Re: Liverpool City Council's Review of Response to Submissions for SSD-10446, 275 Adams Road, Luddenham

Council was invited to provide comments on the proponent's response to submissions for a proposed resource recovery facility.

DRAWING TITLE
LANDSCAPE GENERAL
ARRANGEMENTS PLAN
SHEET 3

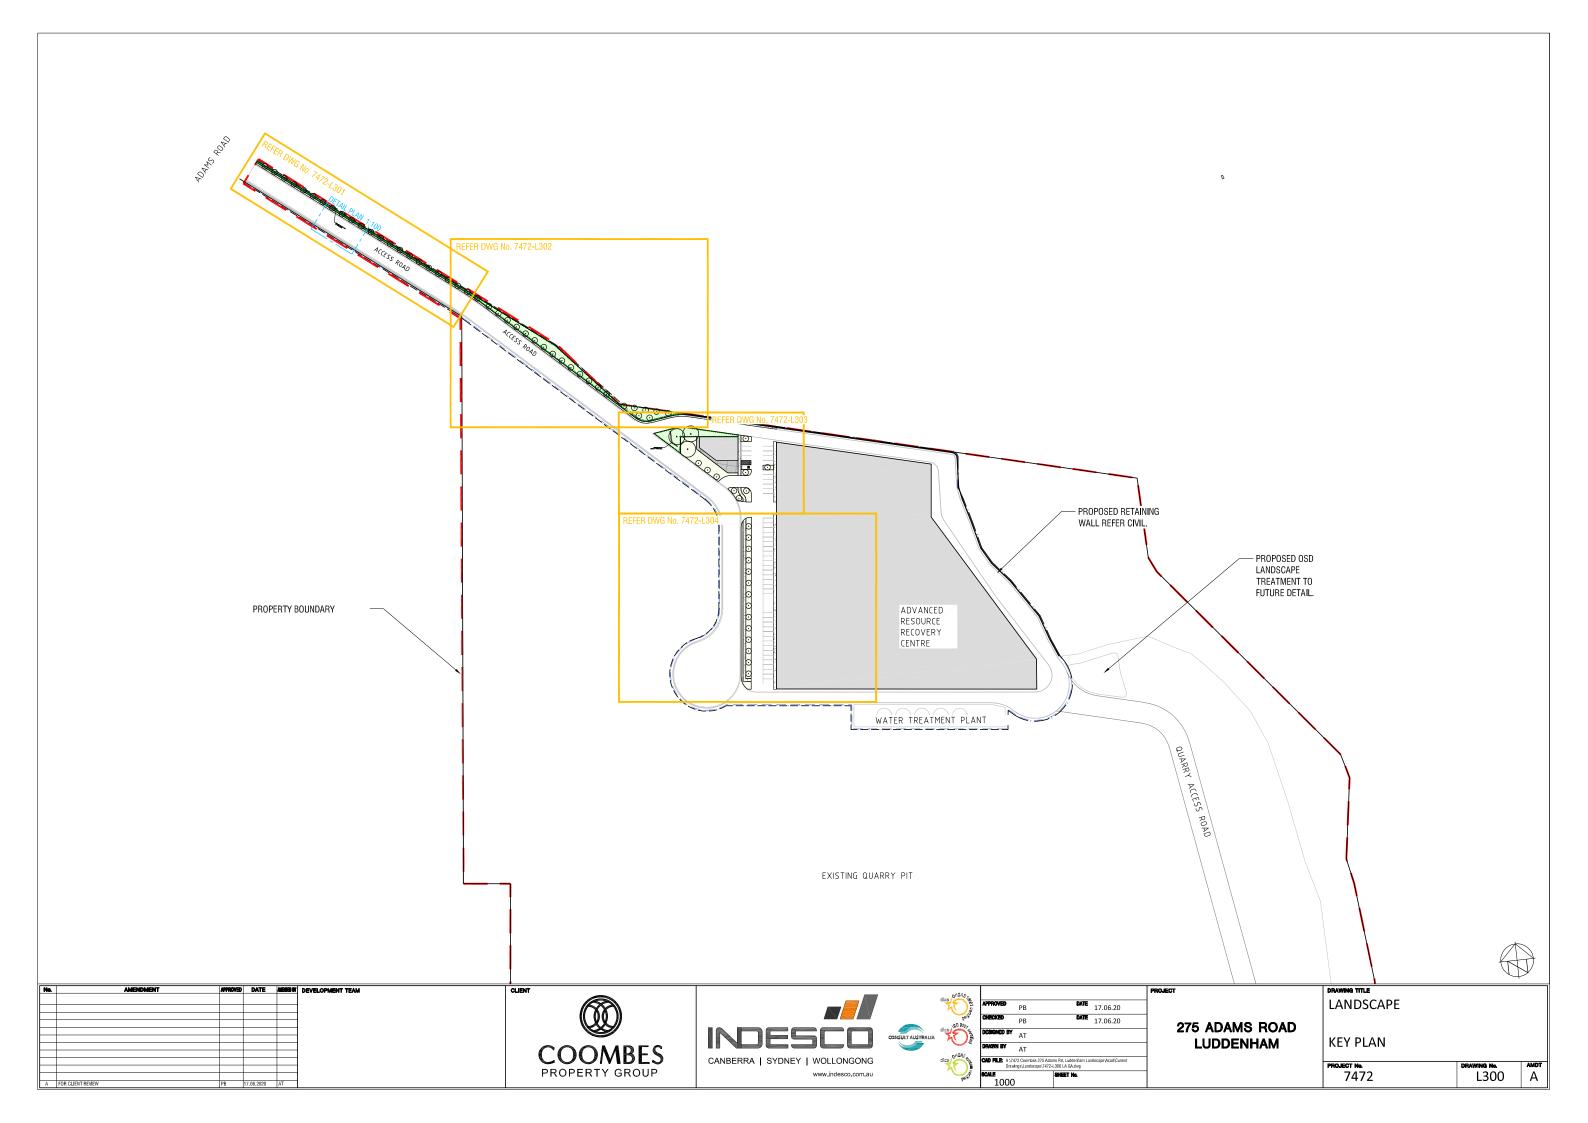
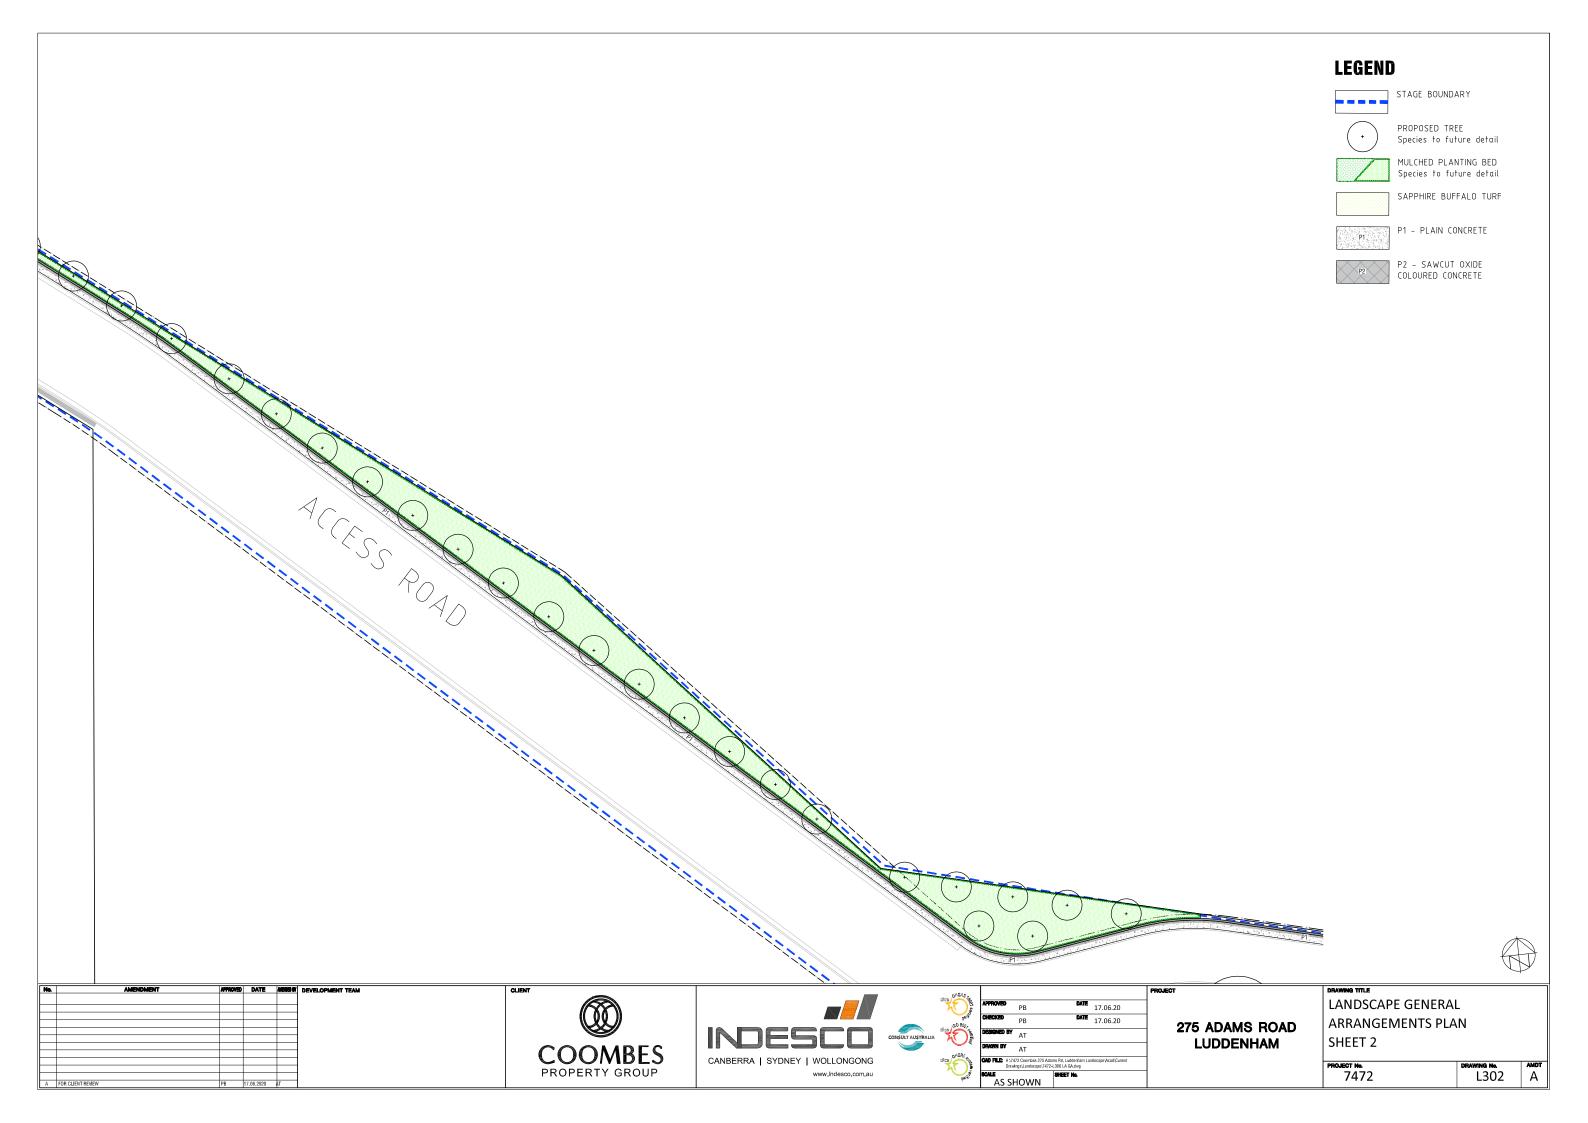
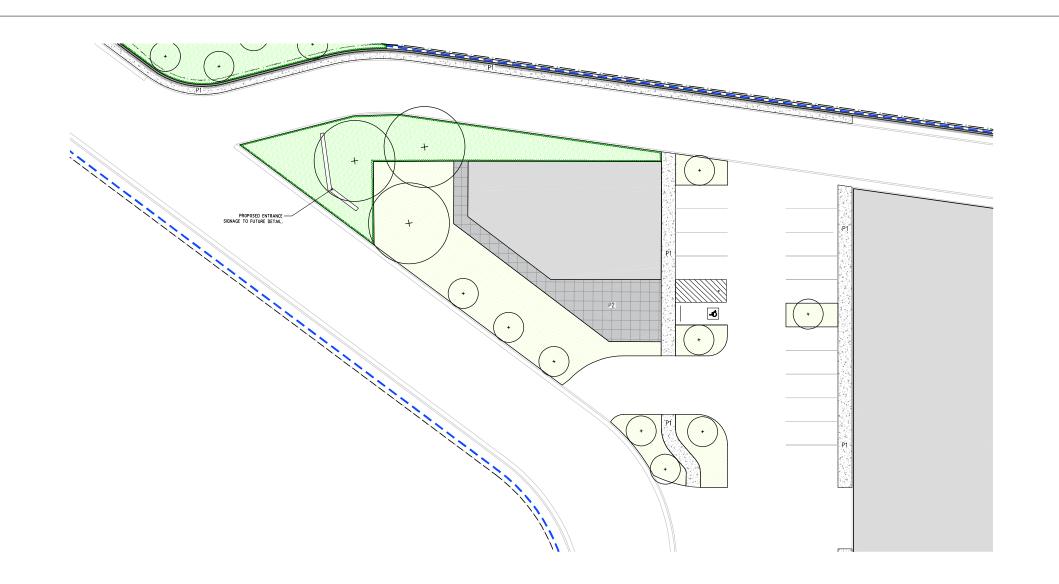
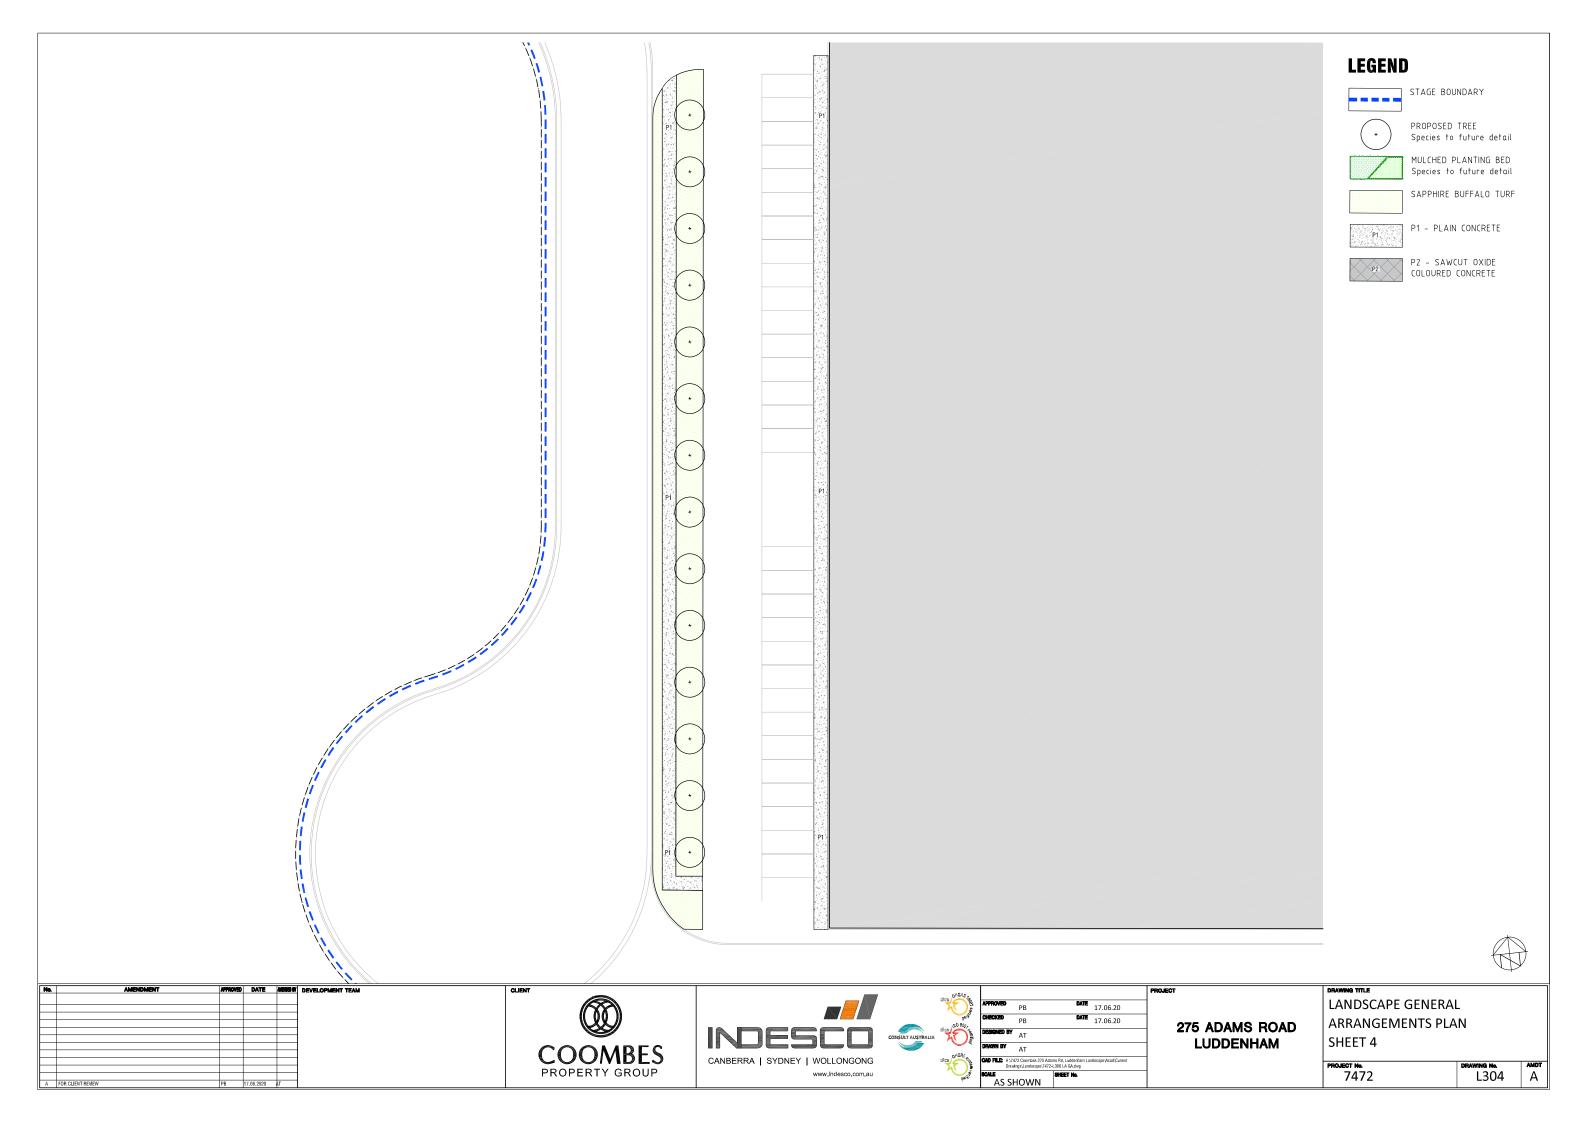
Council staff recommend that DPIE works with the proponent to identify an alternative species to replace areas to be planted with *Acacia longifolia*. The replacement should offer greater longevity and be suited to the conditions/environment in which these trees would be planted. Appendix 2 of Part 1 of Liverpool's DCP has a list of preferred species.
